Your Ref: OWPC17692
Our Ref: FG/27/18/PL 13-02-2018
Please ask for:
Ross Leal

Demolition of care home & redevelopment to provide for apartment building for 7 self-contained flats, cycle parking, bin storage & car parking.

58 Ferringham Lane Ferring

Thank you for your internet representation made on 26th March 2018 which has been recorded as '**an objection**' with the comments as follows:

drawing Existing sections

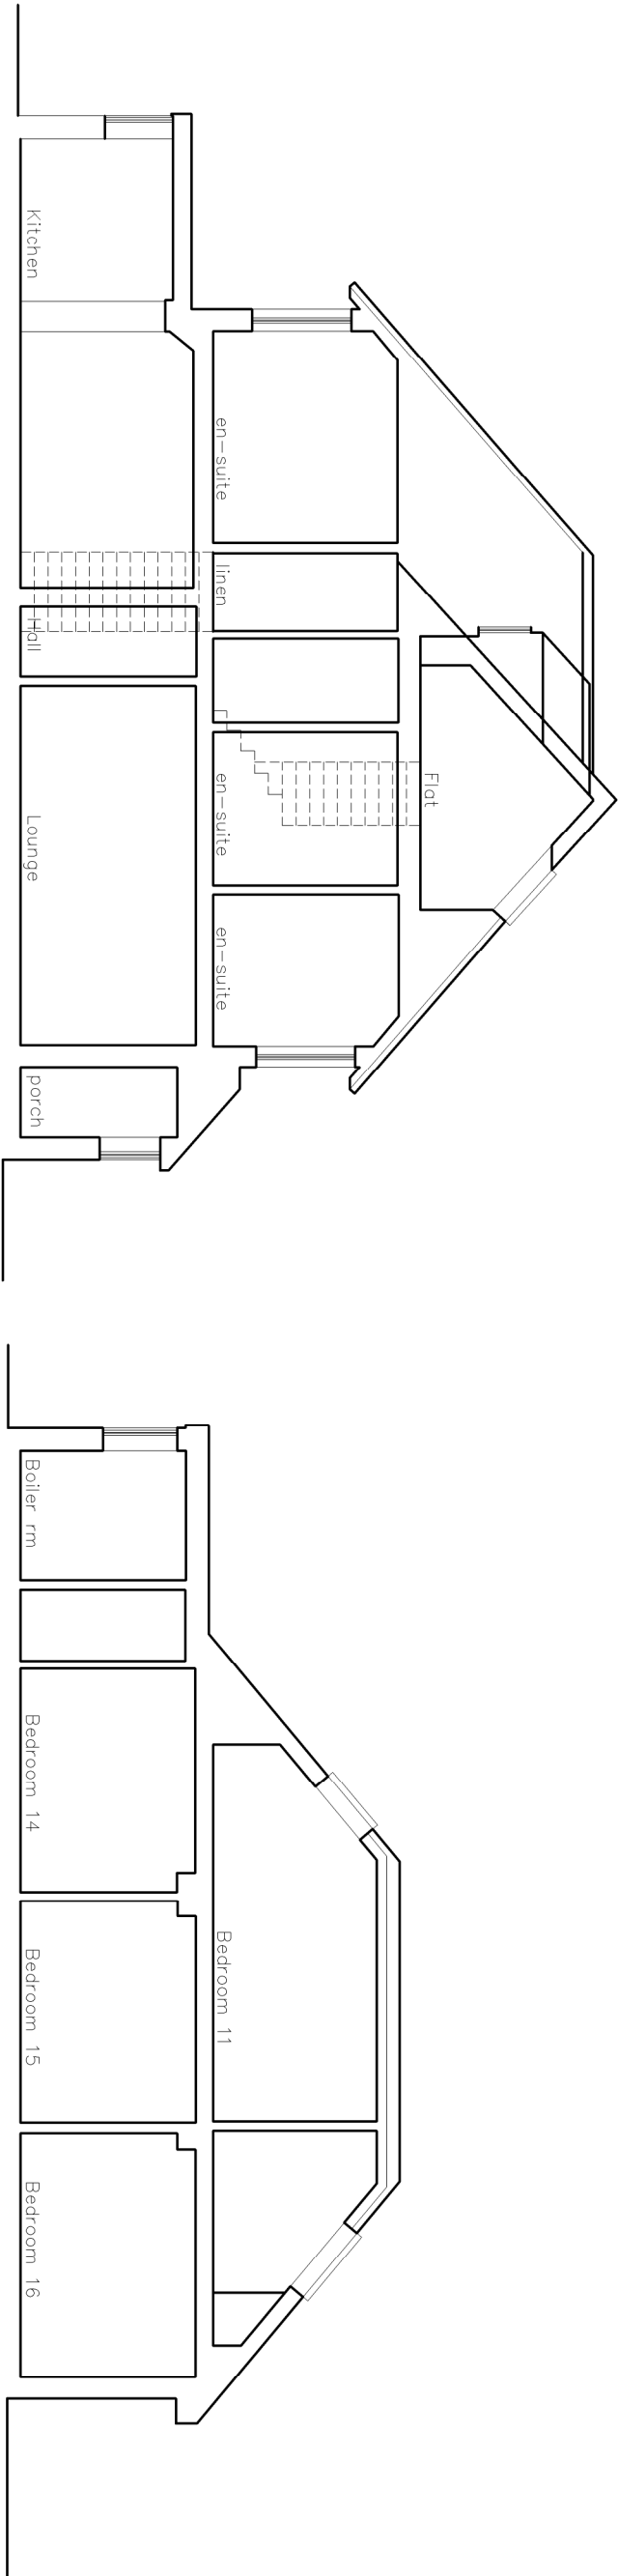
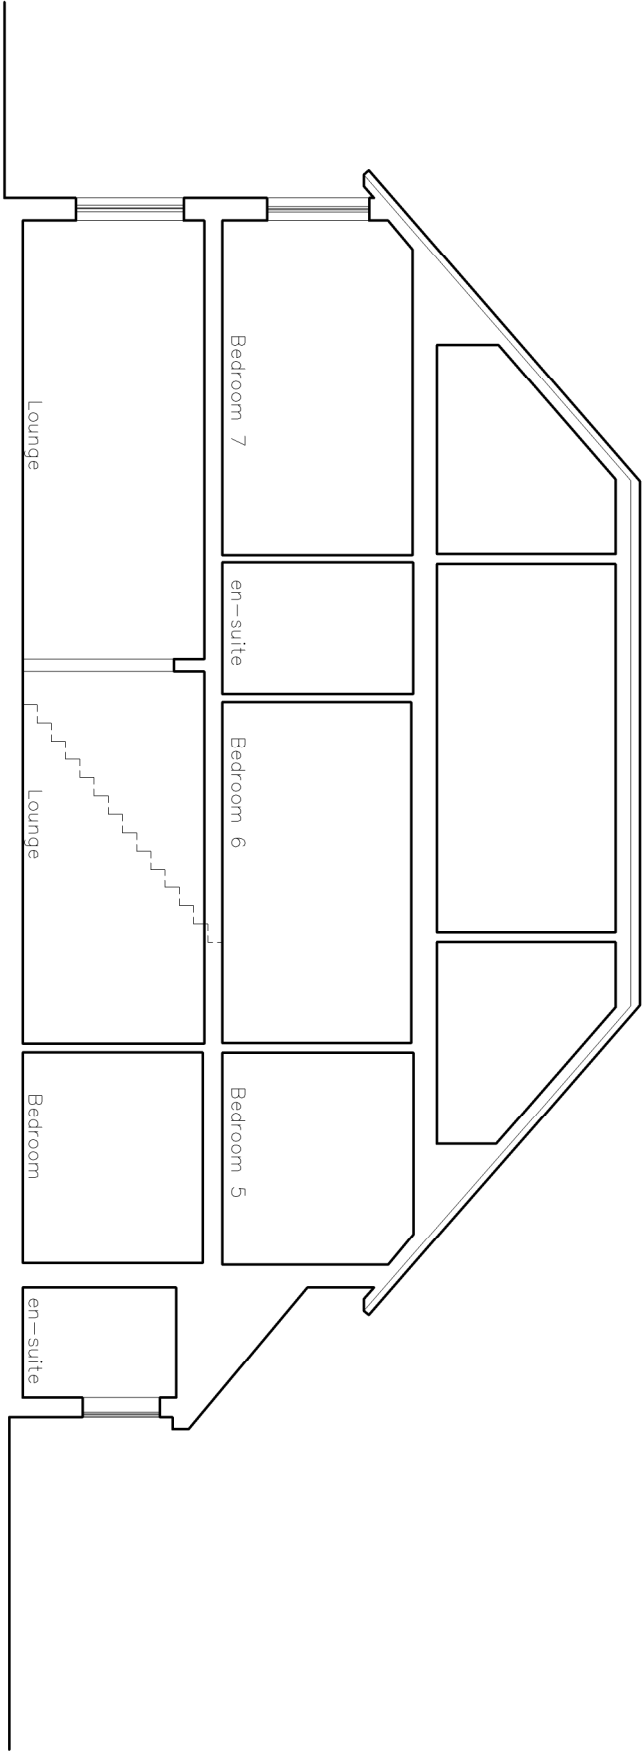
1) Retain the height of the existing building as a maximum. Plans suggest that the height of the new pitched rooves will exceed the current nursing home roof height in places. This is and will be one of the tallest buildings in South Ferring and any addition to the current roof height should not be permitted.

Proposed Access Visibility Splay Plan

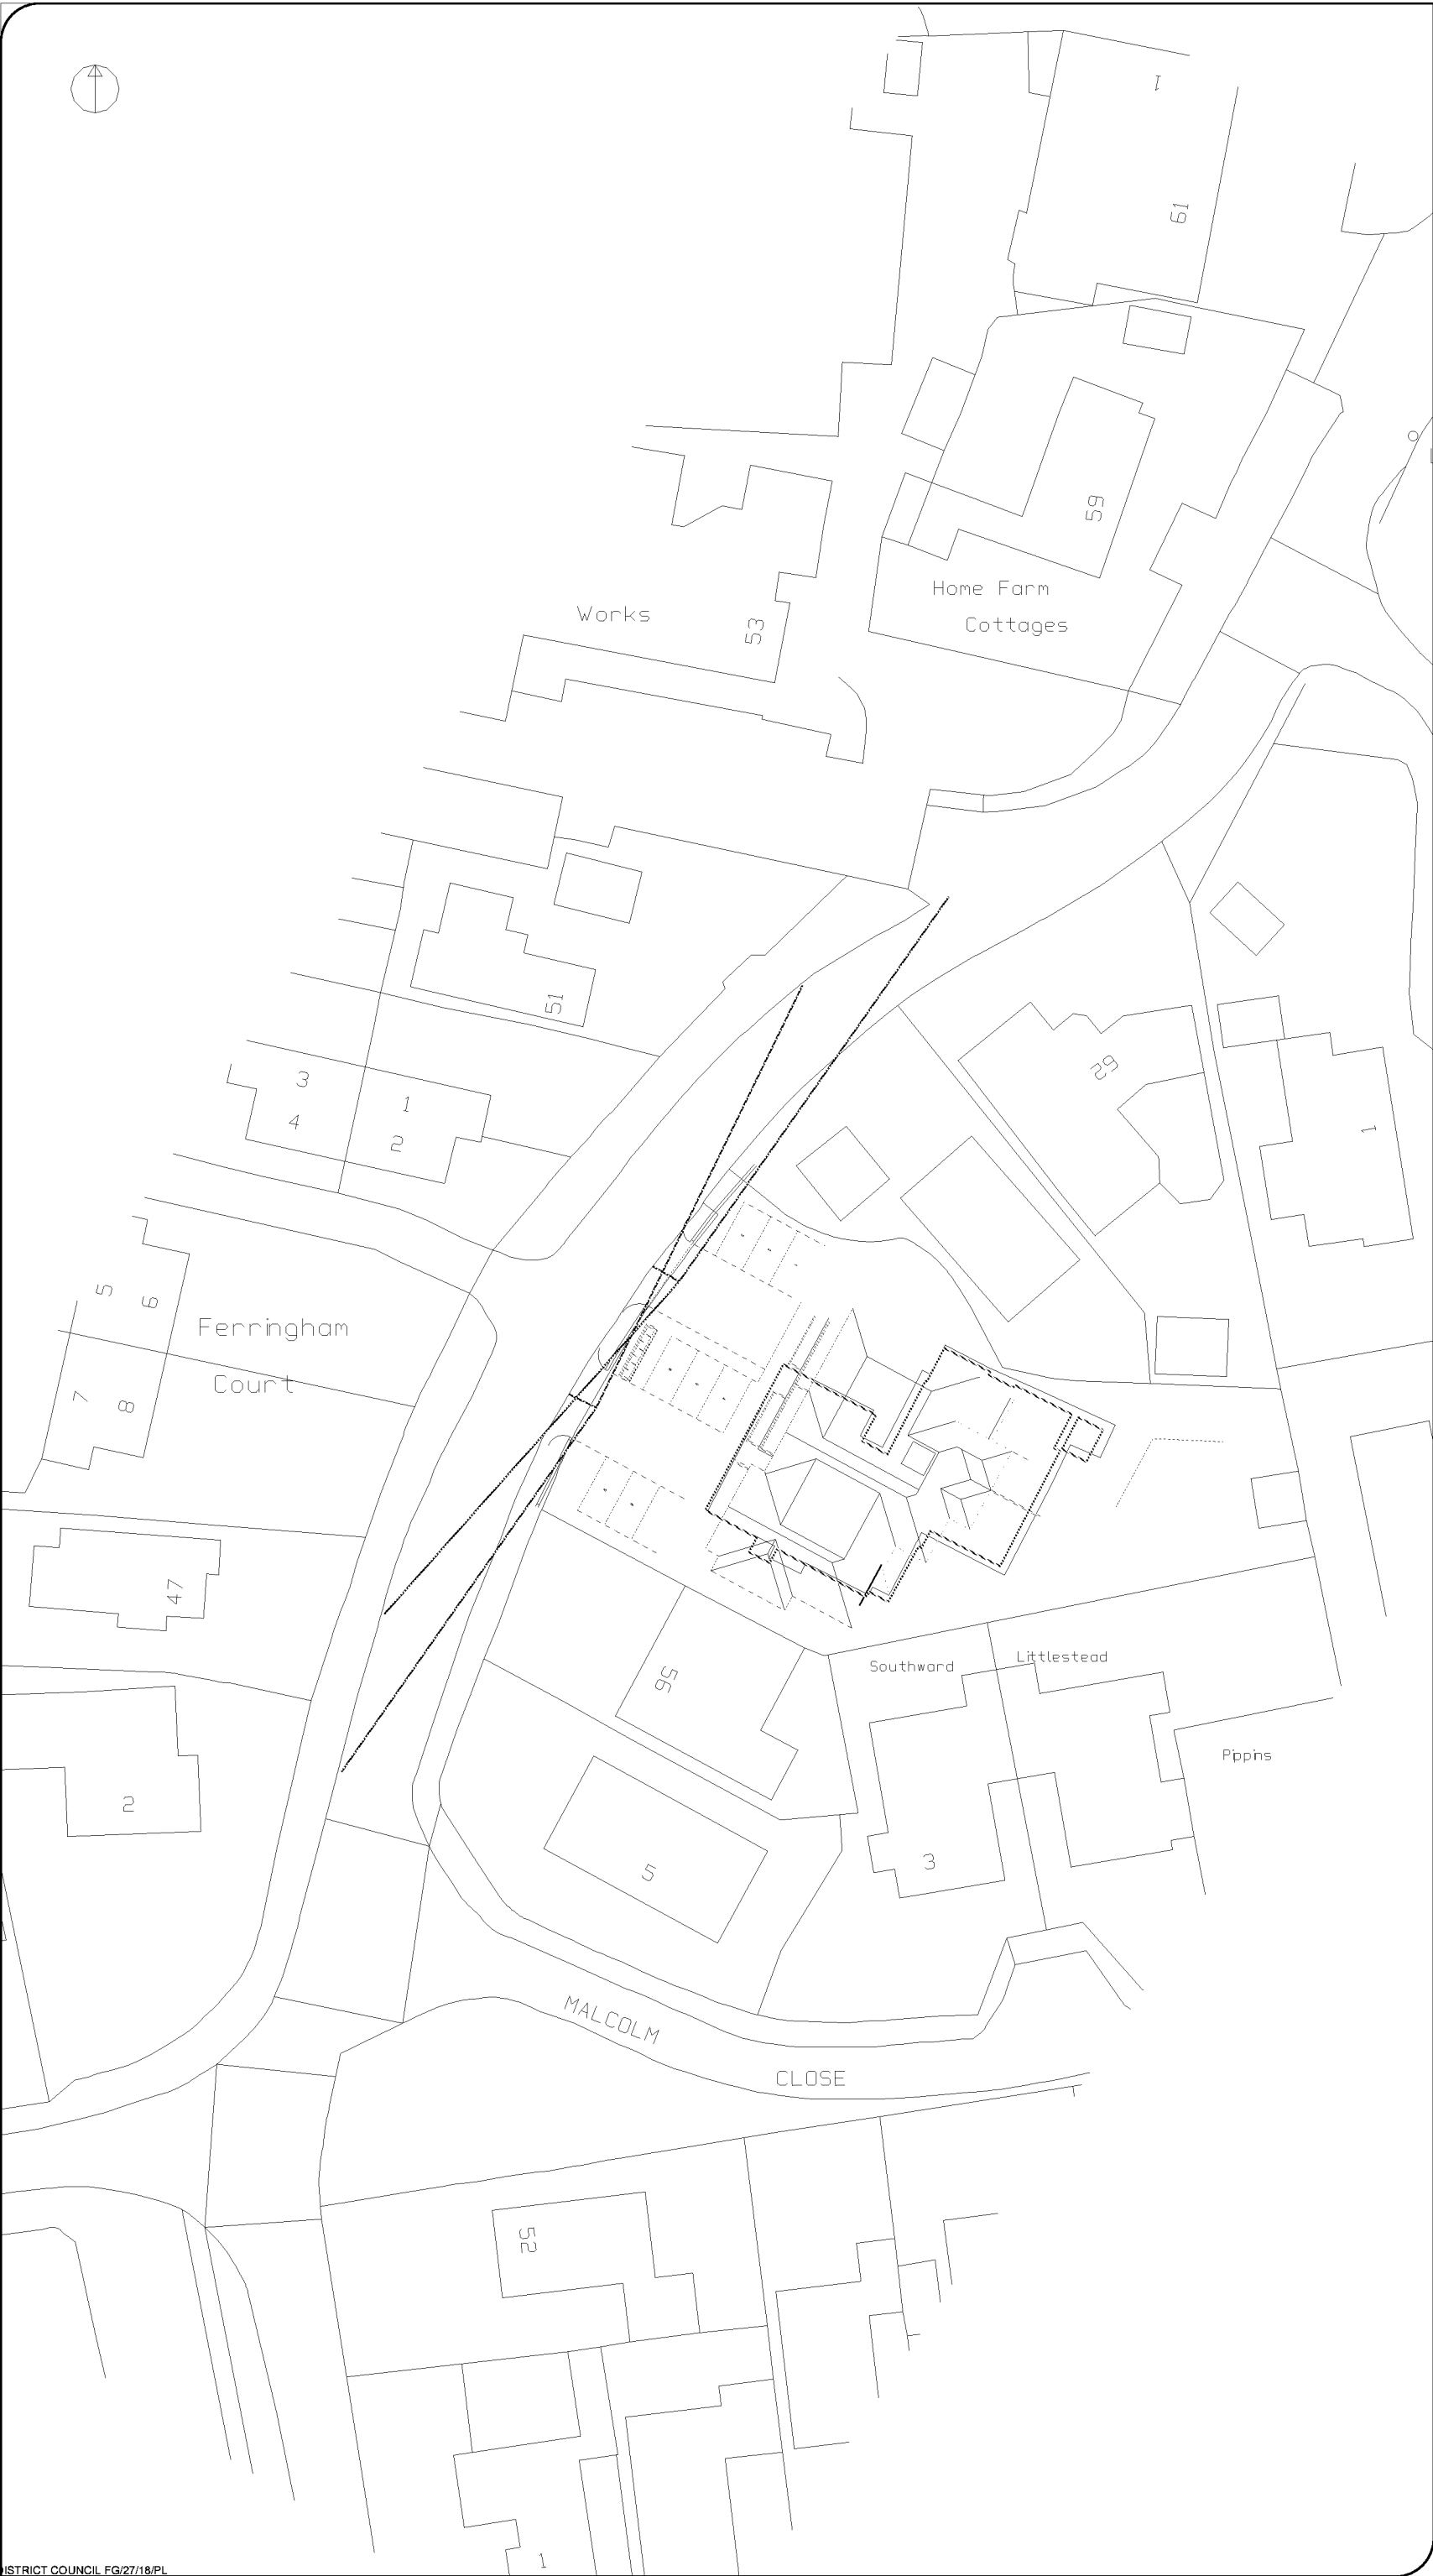
2) Provide more parking spaces on site for the number of residents and likely visitors, deliveries etc. Inadequate parking provision will result in on street parking which is already a growing problem in the village. This location is on a potentially dangerous stretch of the main route through the village, Ferringham Lane, and as things stand the parking provisions appear inadequate.
